Application number: 2023/92933	
What is the application for?:	Demolition of existing dwelling and erection of replacement detached dwelling wi
Address of the site or building:	6, Inglewood Avenue, Birkby, Huddersfield, HD2 2DS
Postcode:	HD2 2DS

Type of comment: An objection	
Do you wish your comments to be published on the website anonymously?	Yes
<p>If we could have, we would have discussed the application with the owners of the property, but they are not living there so we called the architects and managed to speak to Jake a few days ago who knew something about the plans. He said that the lead architect would call back (George) but he has not done so before we need to leave on a holiday. Hence, we were hoping to be able to get comfort on some of the points raised below and not raise them here but despite our best efforts we were not able to do so.</p> <p>We think the proposed development looks really nice for the new owners once completed and we are generally supportive of the development. However, have questions/concerns about three areas – privacy, water drainage and the process. We also are very environmentally conscious and have seen recent press coverage criticising the ca

TITLE
PROPOSED GA PLANS

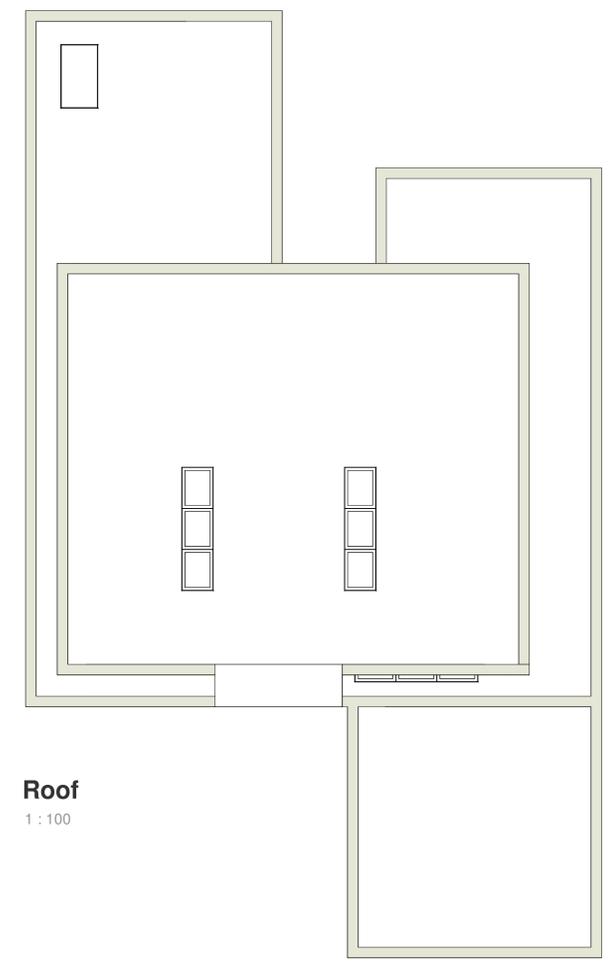
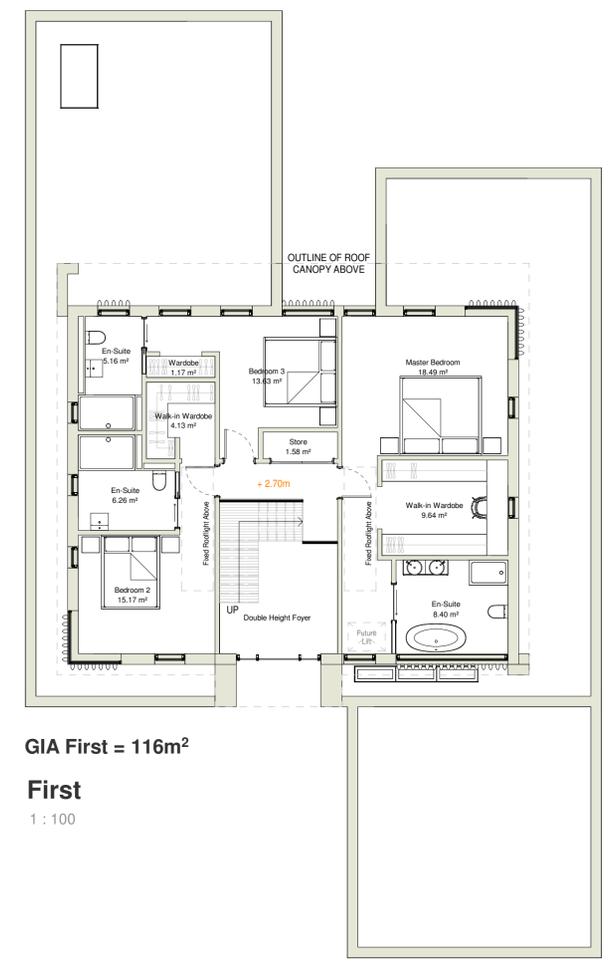
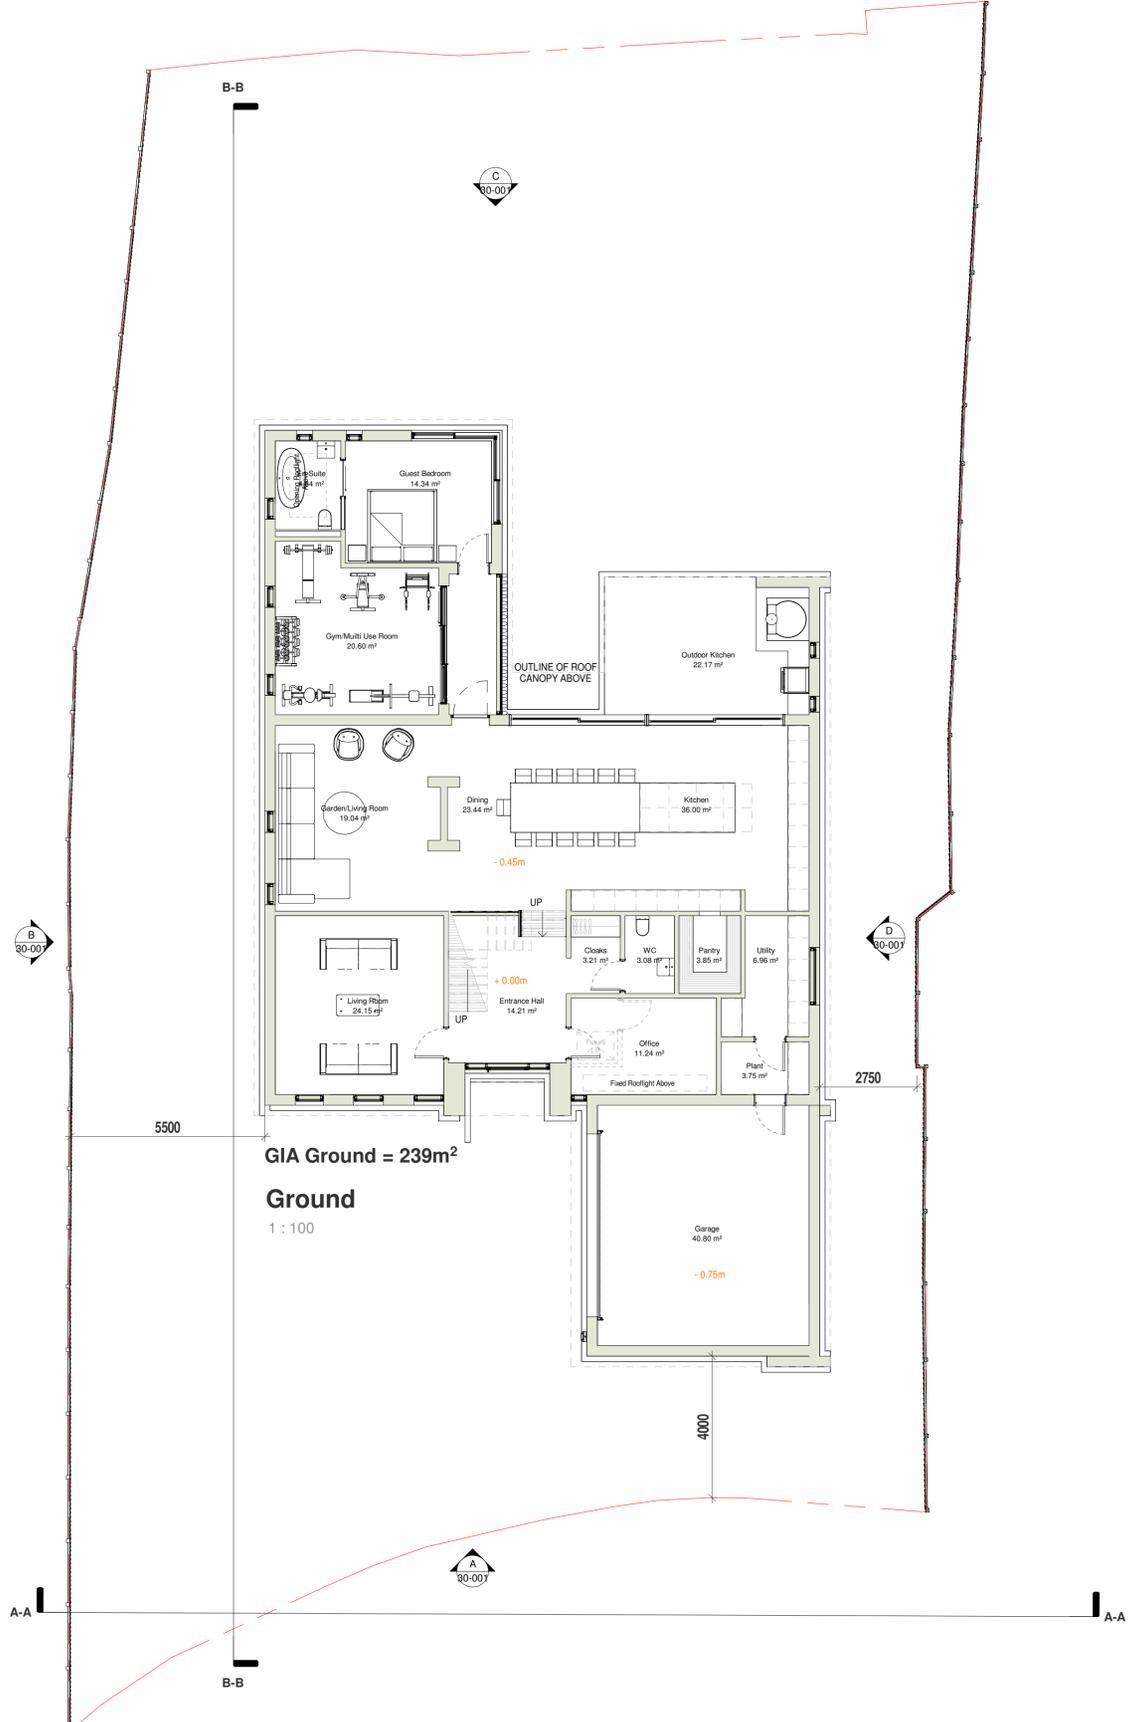
Hence, assuming the assurances received from the architect can be relied upon, there is only one item we object to which is the plan to have windows in one bedroom overlooking our property and therefore impacting our privacy.
